WEST SUSSEX COUNTY COUNCIL CONSULTATION

TO:	Arun District Council FAO: Miss K Welch
FROM:	WSCC - Highways Authority
DATE:	24 November 2020
LOCATION:	81 Orchard Way Bognor Regis PO22 9JZ
SUBJECT:	BR/250/20/HH Installation of dropped kerb to front.
DATE OF SITE VISIT:	n/a
RECOMMENDATION:	Advice
S106 CONTRIBUTION TOTAL:	n/a

81 Orchard Way

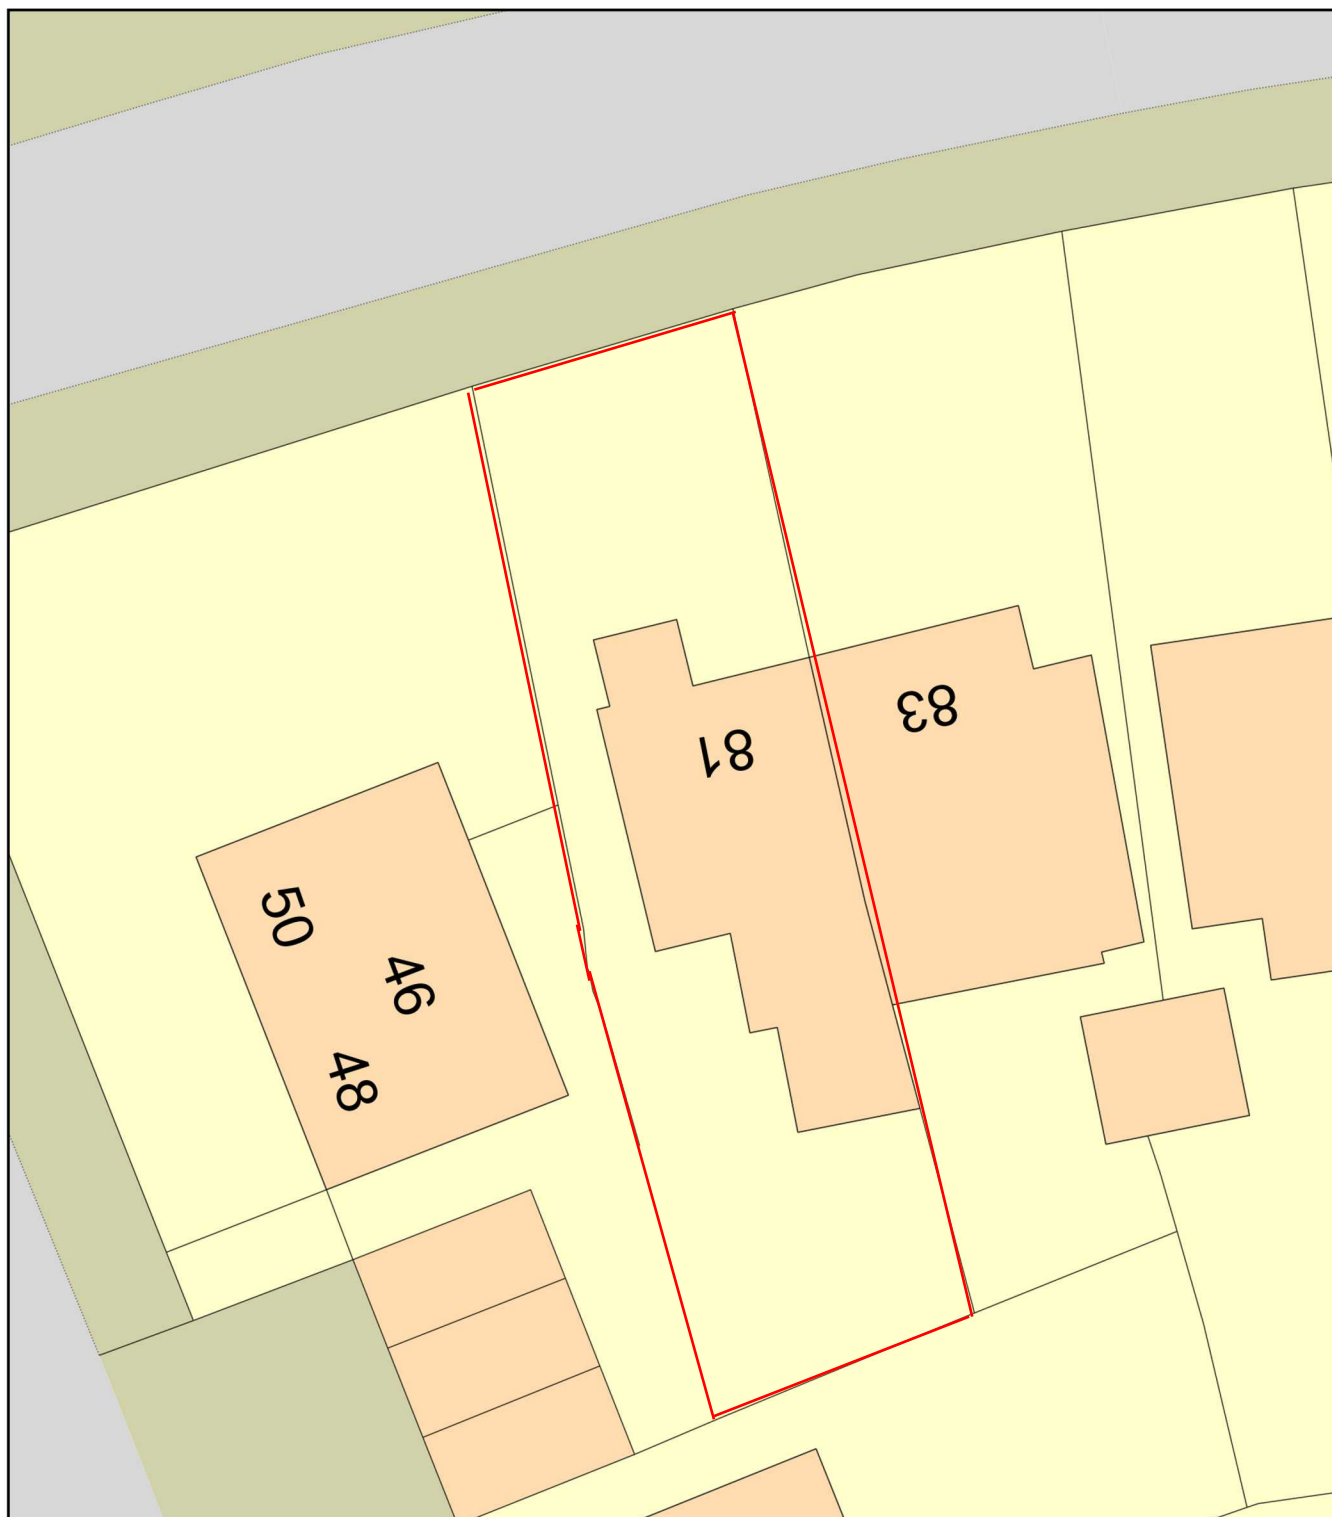
The applicant has provided a visibility splay plan for the proposed vehicle crossover (VCO). The splays do not meet WSCC standards however, the LHA note that splays of 2.4m x 43m are maintainable wholly within the public highway in this location.

The proposed VCO will be 4.6m in width at the carriageway edge. The applicant should be aware that the VCO would be subject to a licence from the Area Engineer and must be constructed to a specification agreed with them.

The VCO will serve a proposed parking area for the existing dwelling, which is anticipated to provide off-street parking for at least two vehicles. A turn on site would be preferred however the LHA acknowledge that this is likely to be unachievable given the site constraints.

The use of the car parking space(s) shall not commence until such time as the vehicular access has been constructed in accordance with the details shown on the drawing titled Location Plan.
